Updated Response to Traffic Matters raised in TfNSW Letter (dated 7/09/21)	
Matter Raised	Response
The network model shows inconsistent cycle times for each intersection. A 120 second cycle time should be used in the network model.	The SIDRA network model has been updated with a cycle time of 120 seconds used for all scenarios. An updated summary table of the SIDRA results is attached.
The network model should consider a scenario where the Rooty Hill Road South/Church Street intersection is not signalised (e.g. left-in/left-out), for the intersections that have been modelled.	A scenario where the intersection of Church Street/RHRS is not signalised (and turning movements are limited to left in/left out) has been analysed. The results are presented in the attached table. This results in additional right turning traffic at the intersection of Rooty Hill Road South (RHRS)/Goldsbro Glade, with the LOS reducing from B to C and the right turn bay on RHRS into Goldsbro Glade overflowing. We note that Council support the proposed traffic signals at the intersection of Church Street/RHRS (improves access to the existing playing fields) and that limiting turning movements to LI/LO would rest

INTERSECTION LAYOUT - TURNING PATHS
SCALE: 1:250@A1

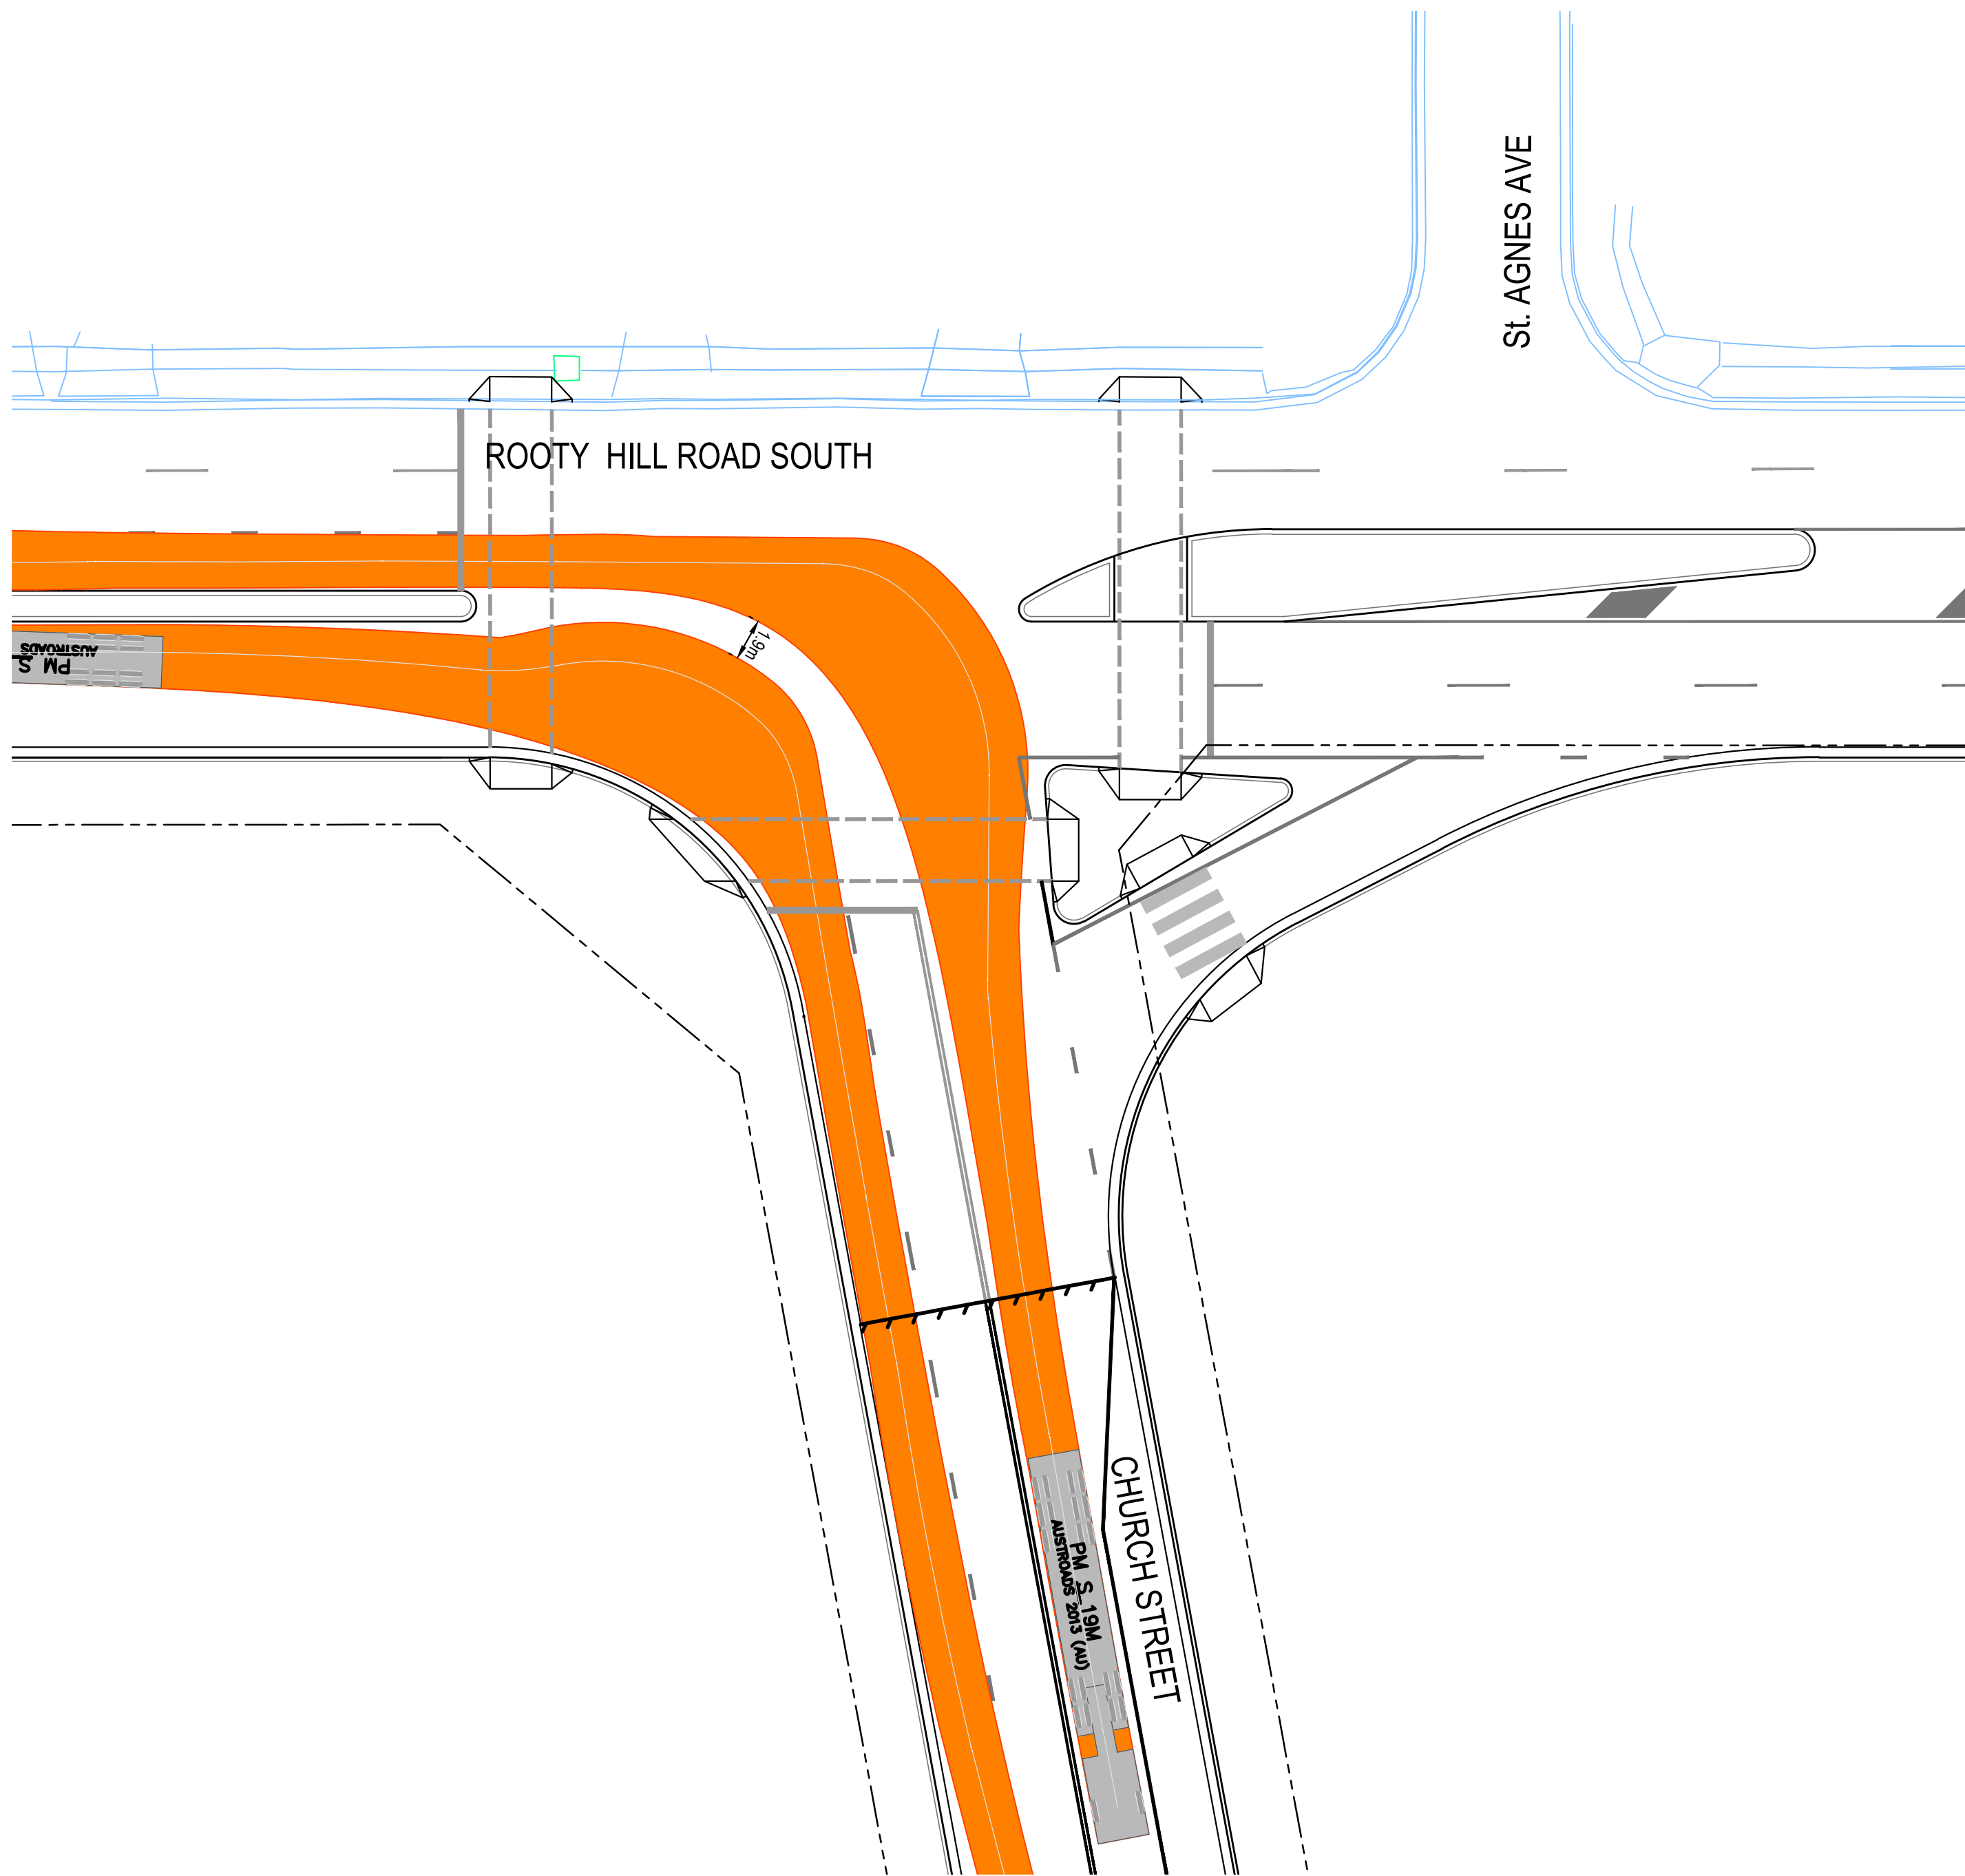
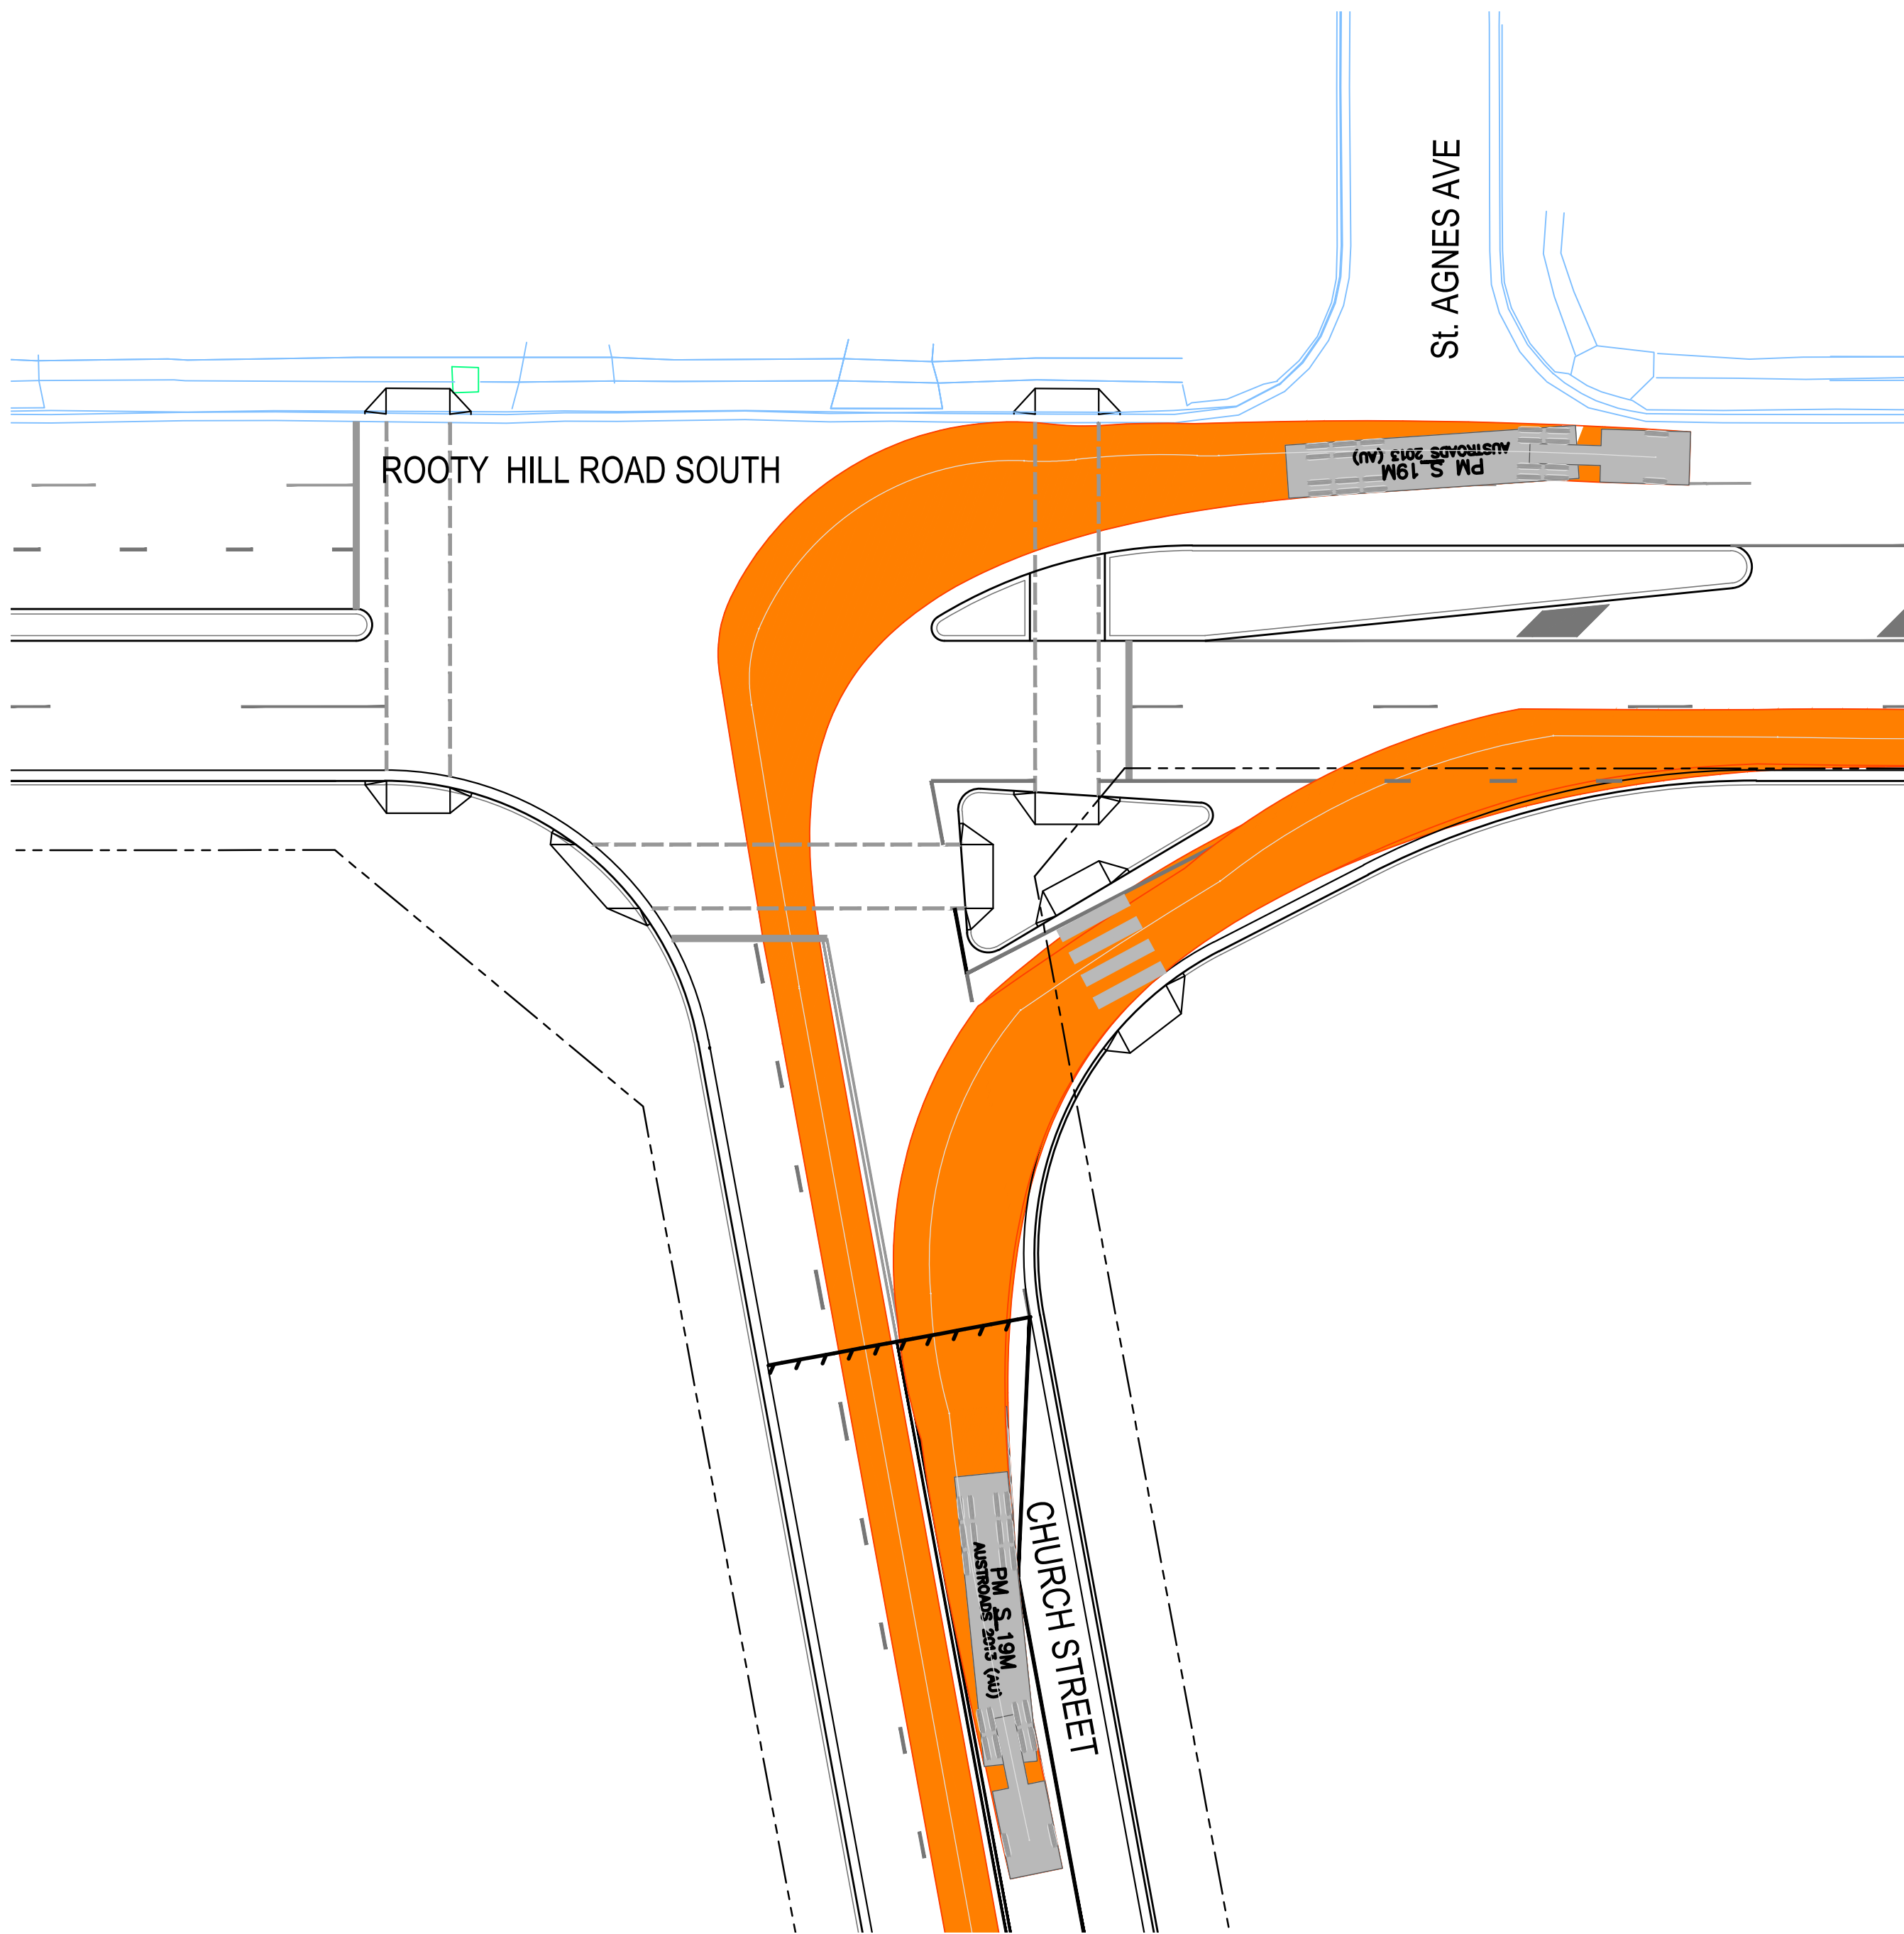
<p>The proposed right turn bay on Rooty Hill Road South seems too short for the estimated Stage 3 trip generation and will likely need to be extended. It is also not clear as to whether this right turn bay is adequate to cater for loading vehicle and the right turn movements.</p>	<p>The 95th percentile queue in the Saturday Midday + 10 years scenario (worst case) is 32m long. The right turn bay into Church Street is 55 metres long. This is considered adequate.</p>
<p>The Rooty Hill Road South/Minchinbury Street intersection would need to have a left-in/left-out treatment. Further information needs to be provided with regard to the redistribution of traffic as a result of this left-in/left-out treatment on the road network.</p>	<p>As per our discussion on 21/10/21, the intersection of RHRS/Minchinbury Street has been made LI/LO. Existing right turning traffic is low (at some 5 to 10 vehicles per hour in the PM peak hour). With right turning movements at Minchinbury Street are removed, alternative access is available via Penfold Street and Cawarra Street to the south.</p>
